**Consultation Response from KC,
Highways Development Management**

2026/90693 Land at, Greenhill Bank Road, New Mill, Holmfirth, HD9 1ER

**Discharge of details reserved by Condition 7. (highway safety) of permission 2023/90346 for
erection of two detached dwellings**

Date Responded: 26/03/2026

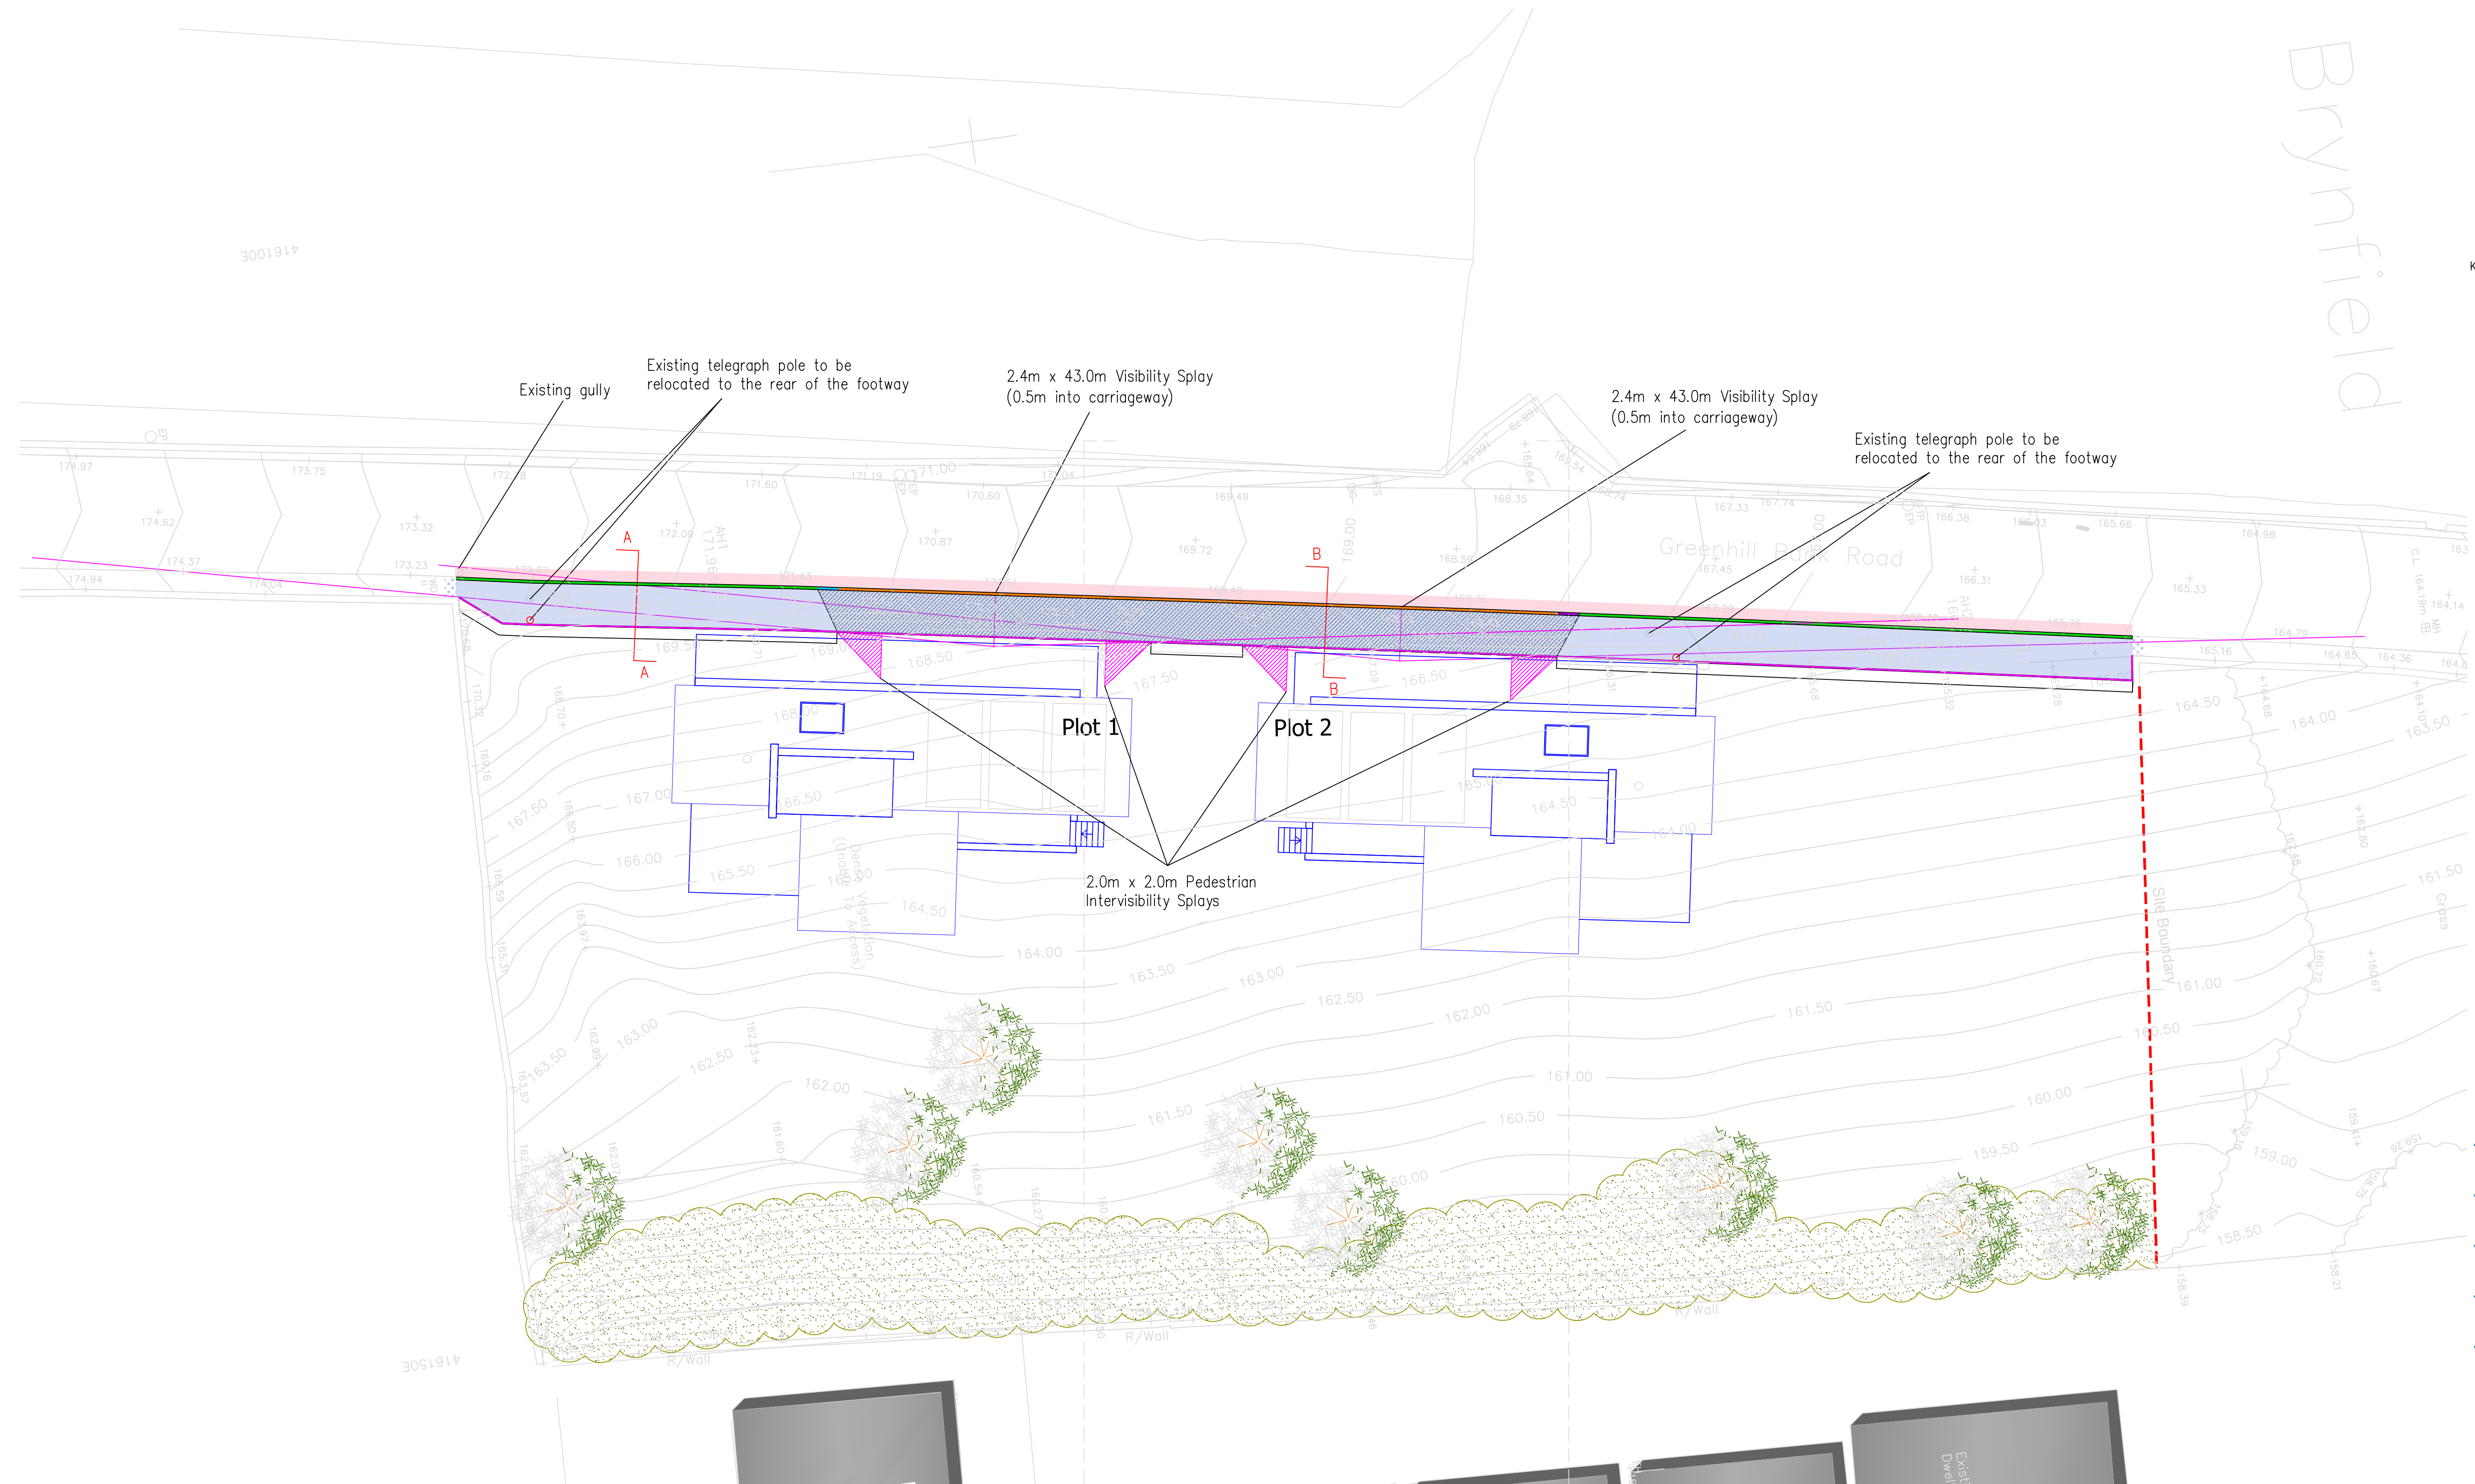
The applicant has provided details showing the 2m footway along the frontage of the site, details of kerbing and construction and surfacing, details of the relocation of telegraph poles, a swept path analysis showing access to the parking spaces is achievable and 2.4m x 43m visibility splays can be achieved. However, we still need to see the independent Stage 1 Road safety Audit.
